From: Juliet Harris [redacted]
Sent: 03 September 2014 12:31
To: Planning
Cc: Nicola Spencer
Subject: Urgent - Consultee Comments on planning applications LU/221/14/PL, LU/222/14/PL, LU/223/14/PL, LU/224/14/PL and LU/227/14/PL
Importance: High

The Town Council's Planning and Transportation Committee considered planning applications LU/221/14/PL, LU/222/14/PL, LU/223/14/PL, LU/224/14/PL and LU/227/14/PL at their meeting held on 26th August 2014.

Given that the application formed part of five individual proposals for the construction of a number of affordable homes in the Joyce Close and Greenfield areas of Littlehampton, the Committee considered that they would have a significant cumulative impact on the area. In view of the close proximity of the sites, Members felt that in order to understand this cumulative impact, it was more appropriate that the plans be assessed collectively, although comments on the individual applications were also considered. The following comments therefore apply individually to each application.

Drawing:
 TEST LOCATION PLAN

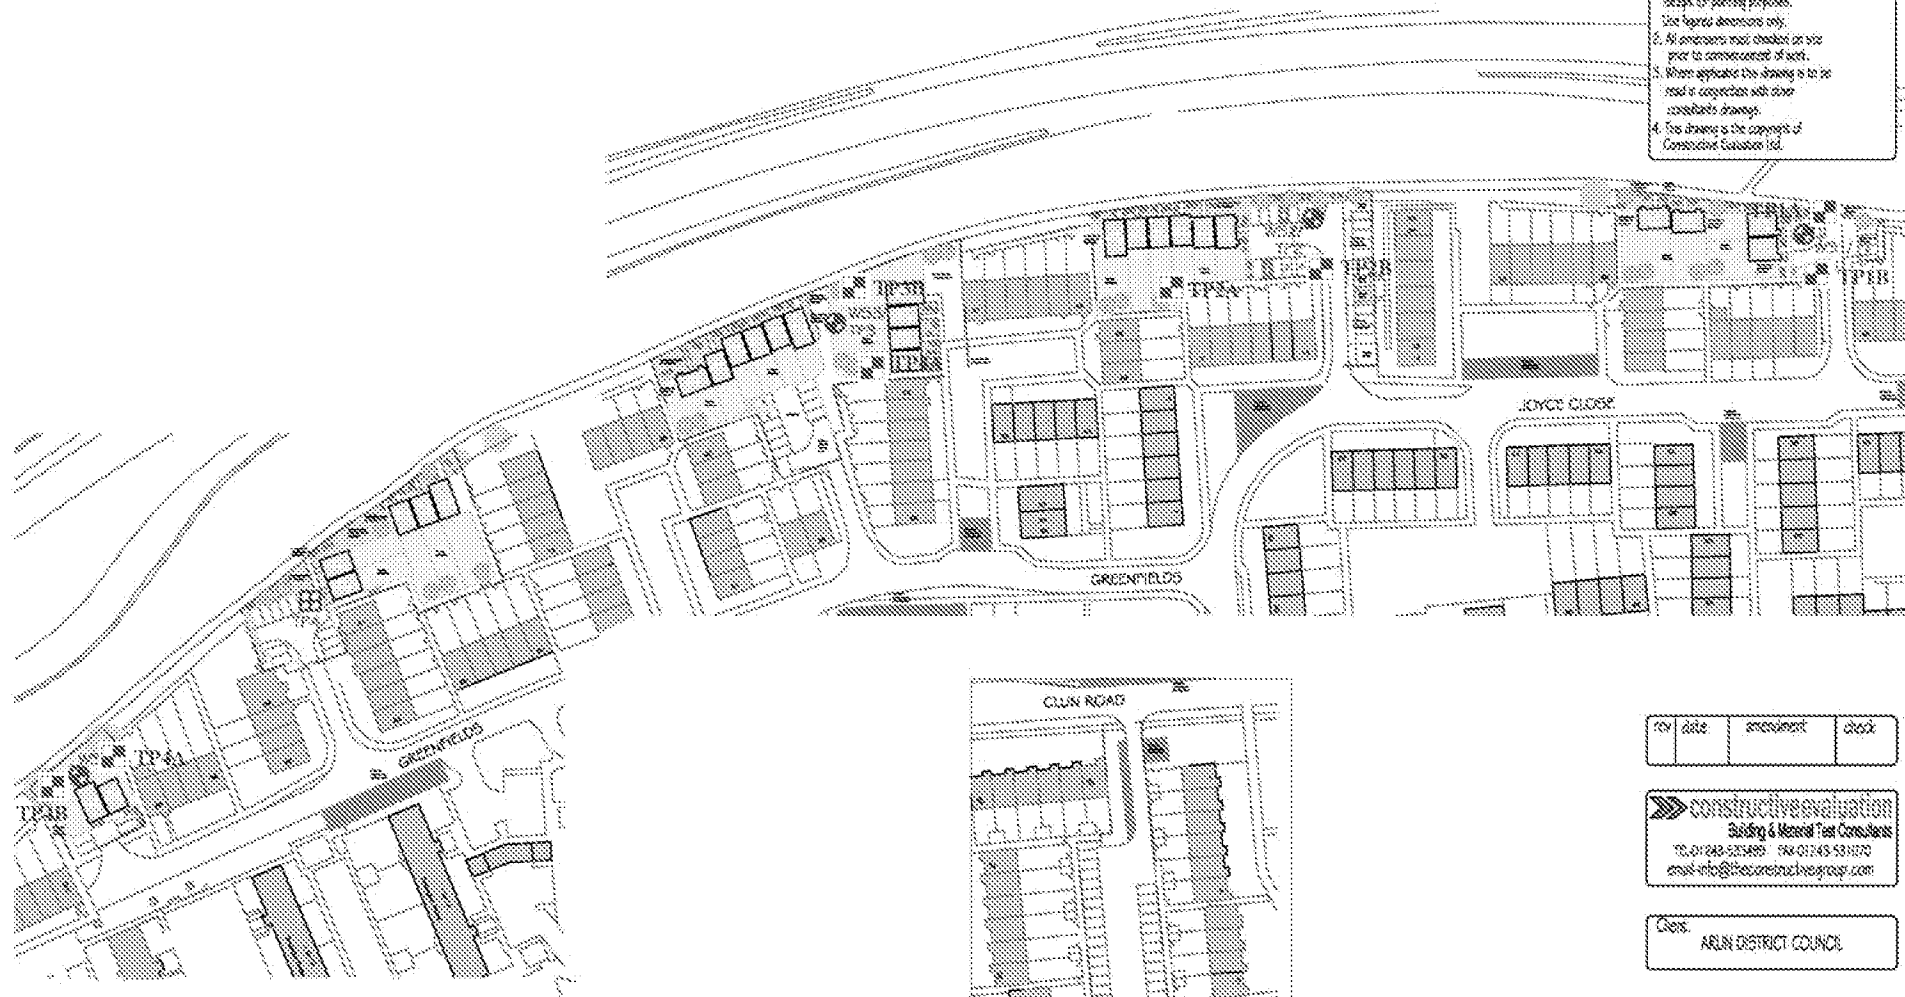
- The infiltration testing of sites LU/221/14 & LU/222/14 showed the best results but these were still not good. Is it appropriate to build more houses if this is a problem?
- It appears that at sites LU/224/14, LU/223/14 & LU/222/14, in spite of renewed testing are showing very slow land drainage. Is it appropriate to build more houses if this is a problem?

Figure 1.2: Development Site Layout

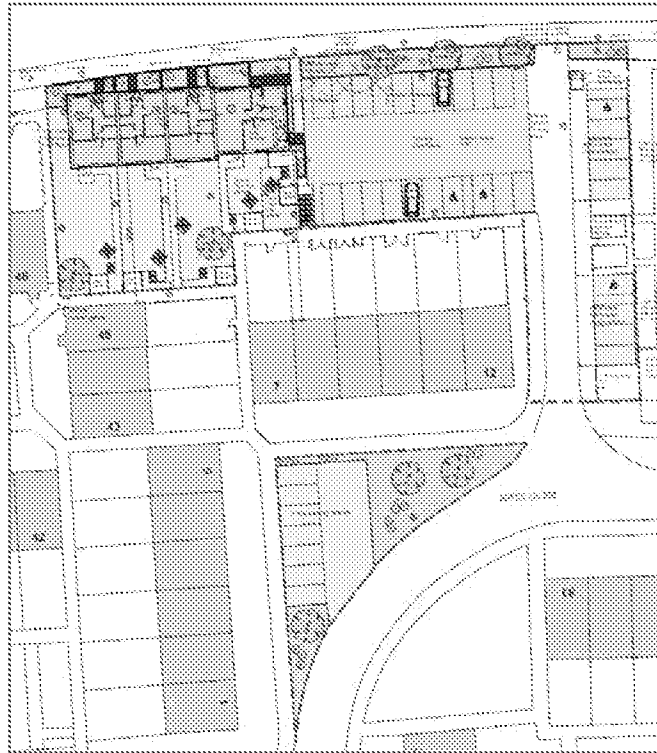
Members also questioned the observation that there was sufficient proposed onsite parking to cater for the increased demand generated by the new development. Based on their knowledge of the area, Members considered that parking in the area was already fully utilised and that the proposed development would exacerbate the problem as the proposed new off street parking was not as accessible to existing residents as the current parking. It was also thought that the assessment of parking survey had been undertaken at an unrepresentative time. Furthermore it was noted that green space and hard standing would have to be sacrificed to provide parking adding to the overall cramming of housing.

- Each site has been assessed separately which for a number of dwellings which do not require a formal Transport Assessment. It is unclear if the applications have been assessed collectively
- The report concludes that *'the site layout allows sufficient room for refuse and service vehicles to negotiate'*. The *'swept path analysis'* is very tight to the new parking bays and would block access to new housing
